CITY OF PORTLAND, MAINE

PLANNING BOARD

April 27, 2016

Project Name:	The Schlotterbeck Block	Project ID:	2016-078
Address:	117 Preble Street	CBL:	033 E001 001 and 033 E005 005
Applicant:	Schlotterbeck Block, LLC		
Planner:	Shukria Wiar

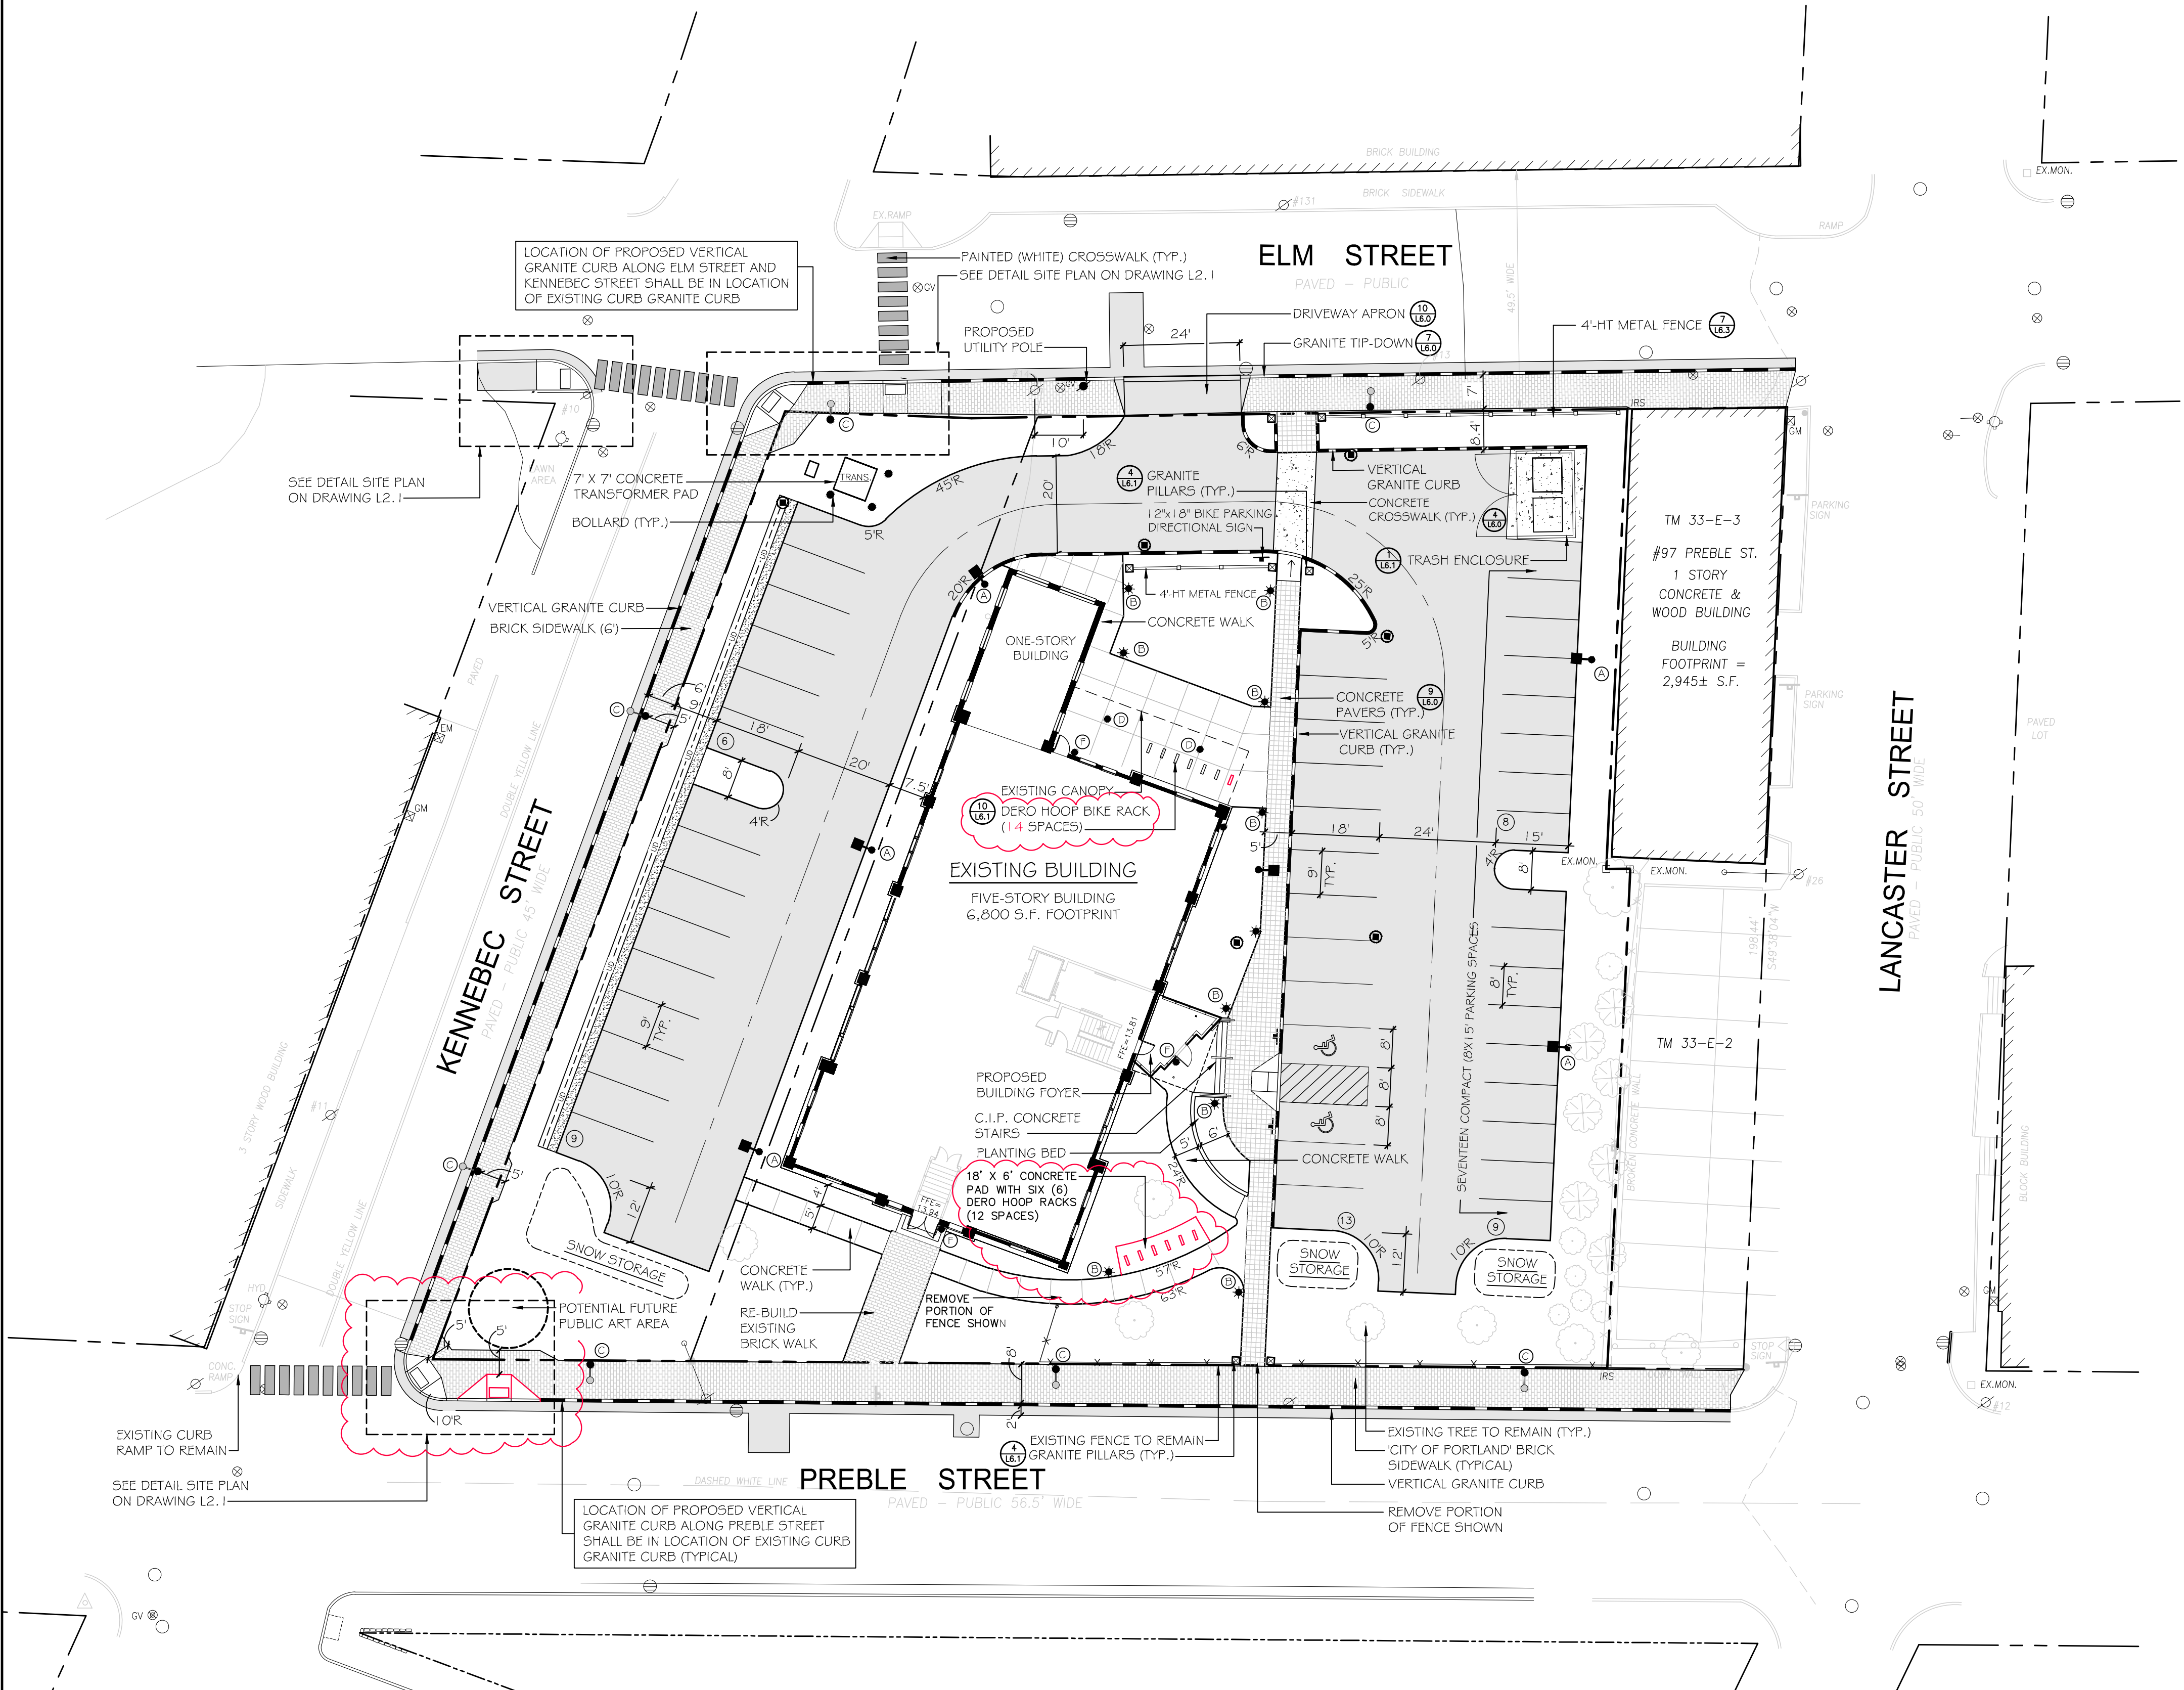
1. **Additional Bicycle Racks:** The additional unit eliminates the bicycle storage room in the basement. As a result, fourteen (14) bicycle parking spaces need to be located on the site. The attached revised L2.0 show an additional bicycle hitch under the canopy and six (6) exterior bicycle racks on a concrete pad located near the building entrance. With these revisions, thirteen (13) bicycle loops are provided and 26 bicycle parking spaces will be provided.

5. **Additional Sidewalk Ramp and Pedestrian Easement:** The City's staff has requested an additional sidewalk ramp at the intersection of Preble and Kennebec Streets, as part of the December 2015 conditions of approval. The new ramp will require pedestrian easement on the

applicant's lot. The attached Amended Subdivision Plan and sheet L2.0 show the new sidewalk ramp and the pedestrian easement.

I find the changes to bicycle parking to be acceptable.

The applicant has provided a detail for the sidewalk ramps at the corner of Preble Street and Kennebec Street. The general configuration is acceptable. Some adjustments are suggested for consideration including 7-foot tip-down curbs at the Preble Street ramps. The City generally prefers a minimum 4-foot separation between ramps. I need to coordinate with DPW on this detail. The plan seems to indicate a low curb reveal between ramps that doesn't meet City standards. I would suggest that a condition of approval be required that notes final ramp details to be provided for review and approval prior to construction.

1. The final details for the design of the ramps at Kennebec and Preble Streets shall be reviewed by City staff and any possible adjustment shall be coordinated with Department of Public Works and the Planning Division, prior to the construction of the ramps.
2. The proposed new six-inch sanitary sewer connection to the sewer main in Elm Street shall be made with an INSERTA TEE connection, (not a saddle Y attached with stainless steel bands). This detail shall be shown on the final plan.

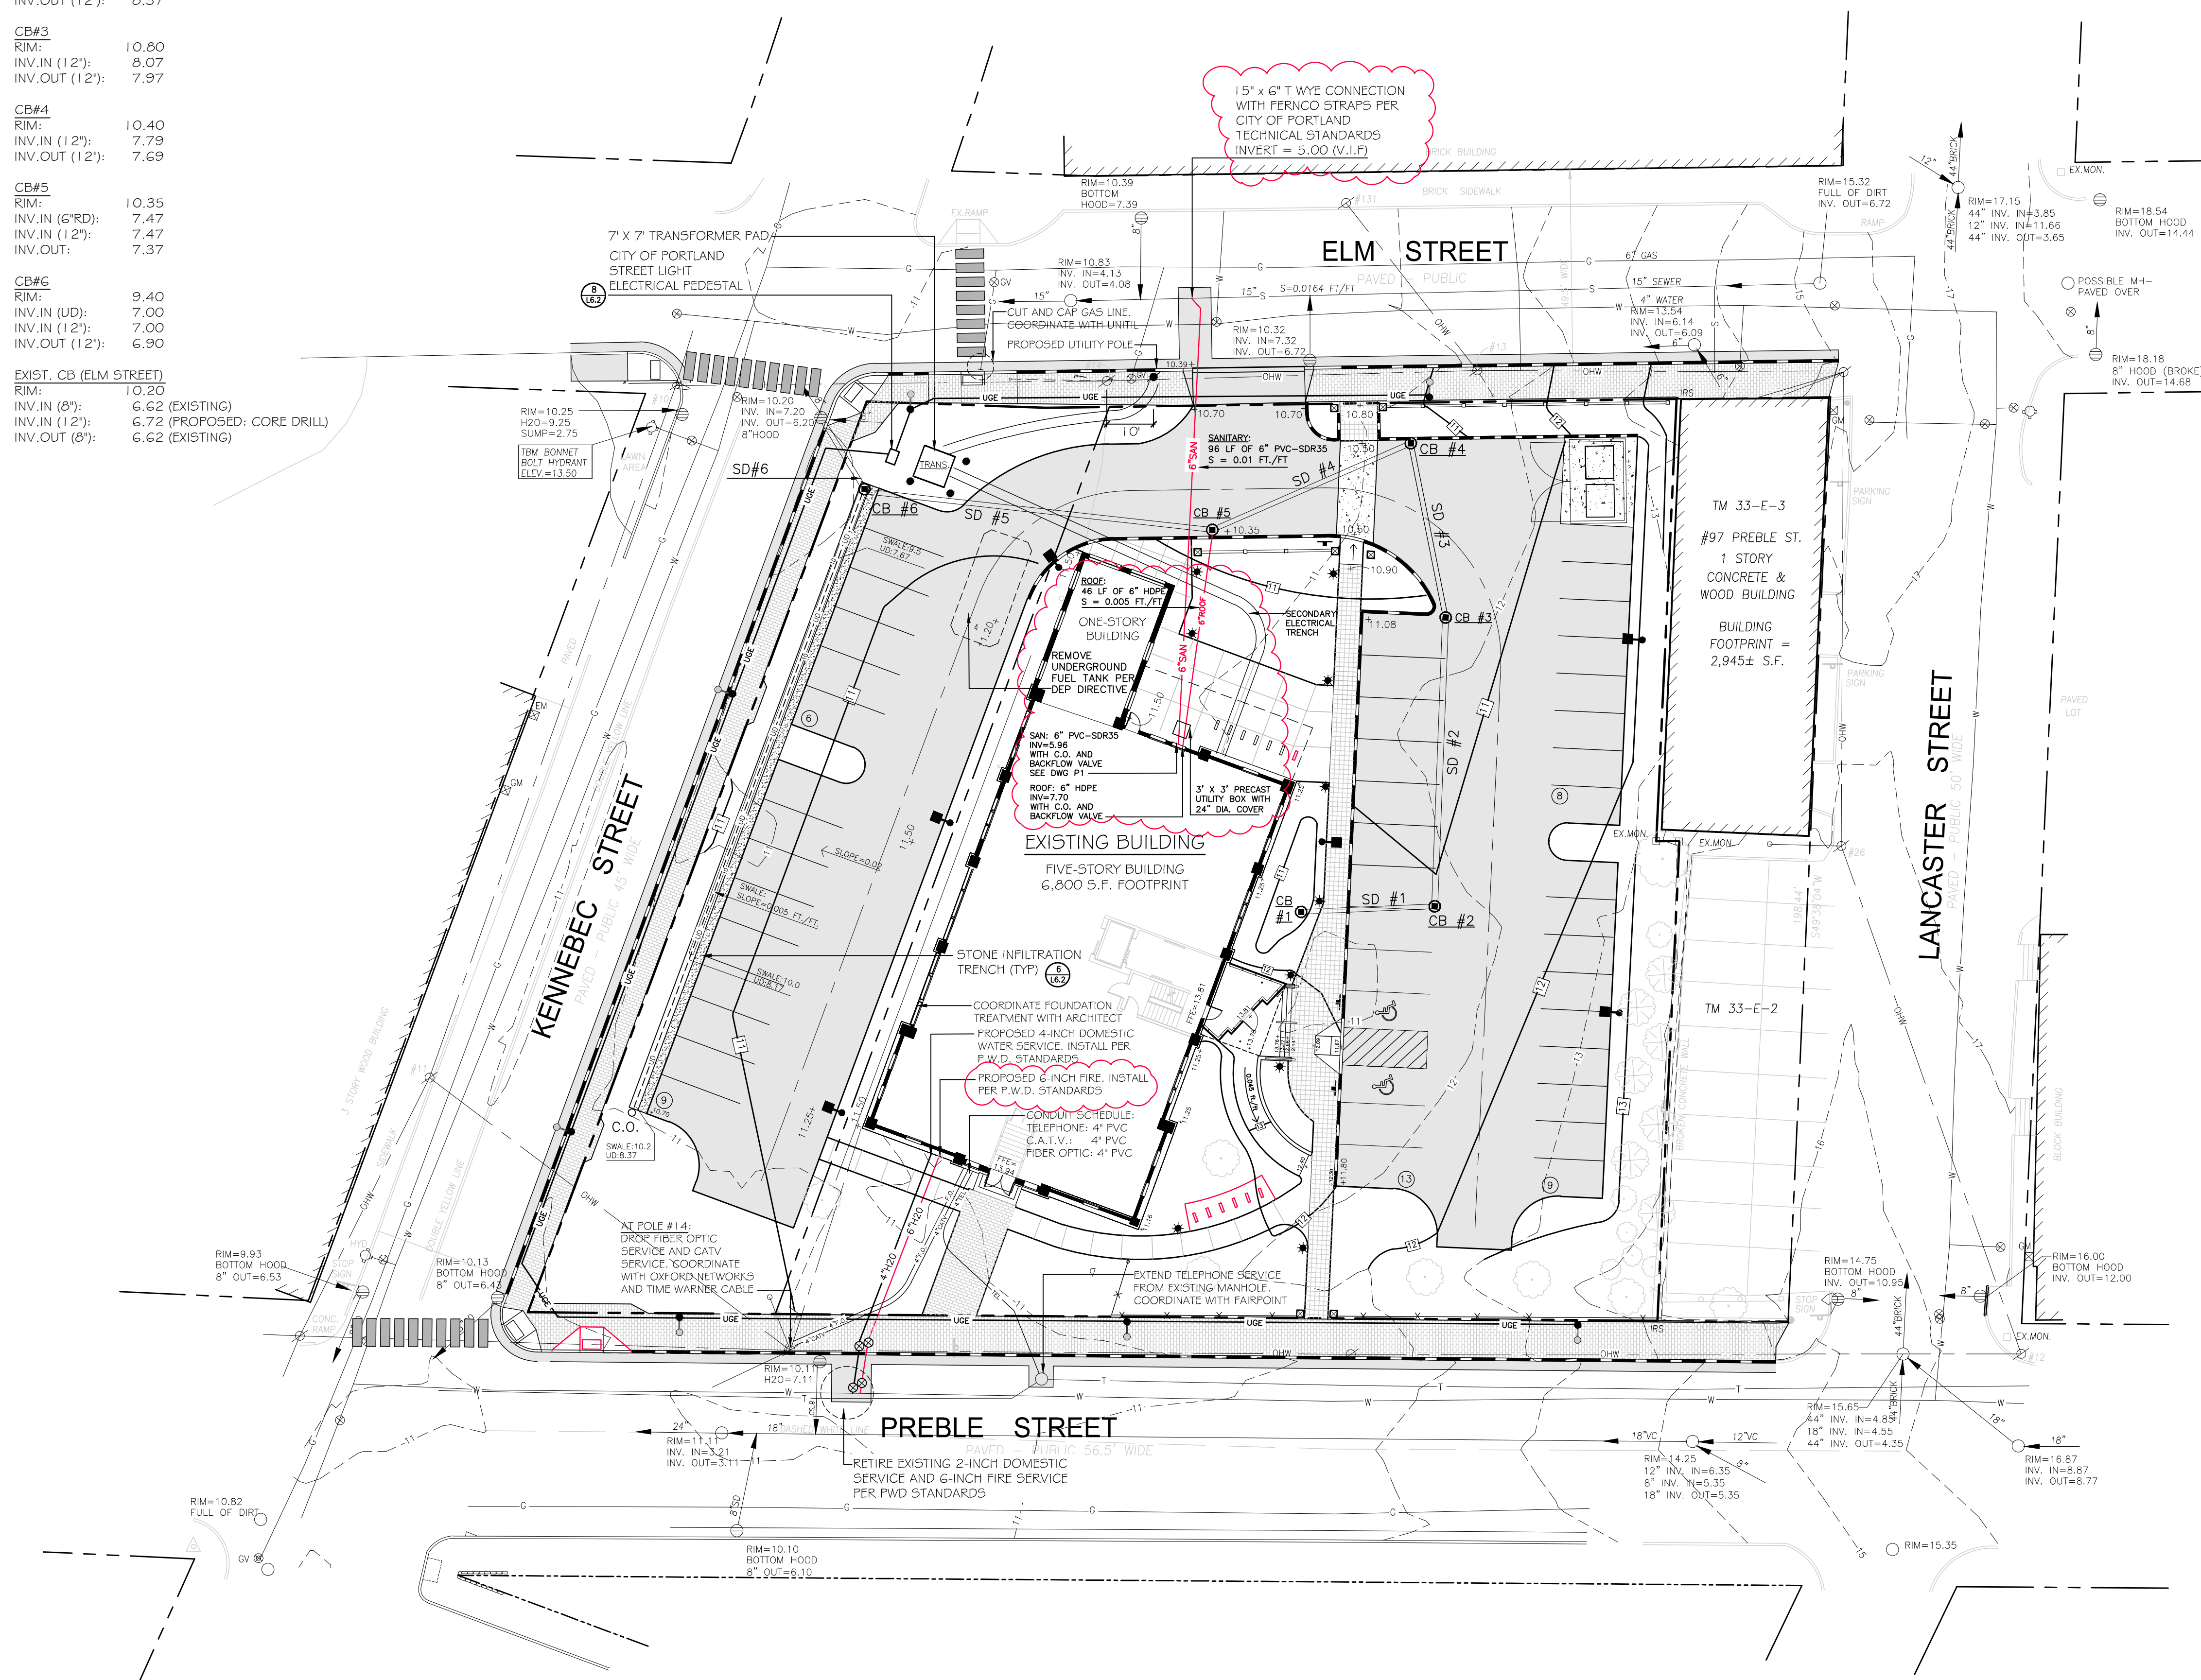
1. The proposed new six-inch sanitary sewer connection to the sewer main in Elm Street shall be made with an INSERTA TEE connection (not a saddle Y attached with stainless steel bands). This detail shall be shown on the final plan.

3. **Roof Drain Connection:** Attached revised L3.0 shows a new 6" HDPE roof drain connecting to catch basin #5. The existing roof drain pipe is in poor condition and needs to be replaced.

4. **Sanitary Sewer Line:** Excavation exploration revealed the existing 6-inch cast iron sanitary sewer line is in poor condition. The applicant proposes to replace the existing sewer line with a new PVC sewer in approximately the same location and wye connect the 15-inch combined sewer on Elm Street.

As part of the amendment application, a new roof drain connection and replacement of an existing sewer line with a new PVC sewer is being proposed. Michael Farmer, Assistant Engineer, has reviewed the upgrades for the Department of Public Services and has the following recommendation:

The proposed new 6" sanitary sewer connection to the sewer main in Elm Street is OK. However, the connection should be made with an INSERTA TEE, (not a saddle Y attached with stainless steel bands), provided that the 15-inch sewer main is structurally sound. If the City inspector finds that the existing sewer main is not structurally sound, he or she may request that a new, replacement section of the existing main be installed with a factory manufactured T or Y fitting.
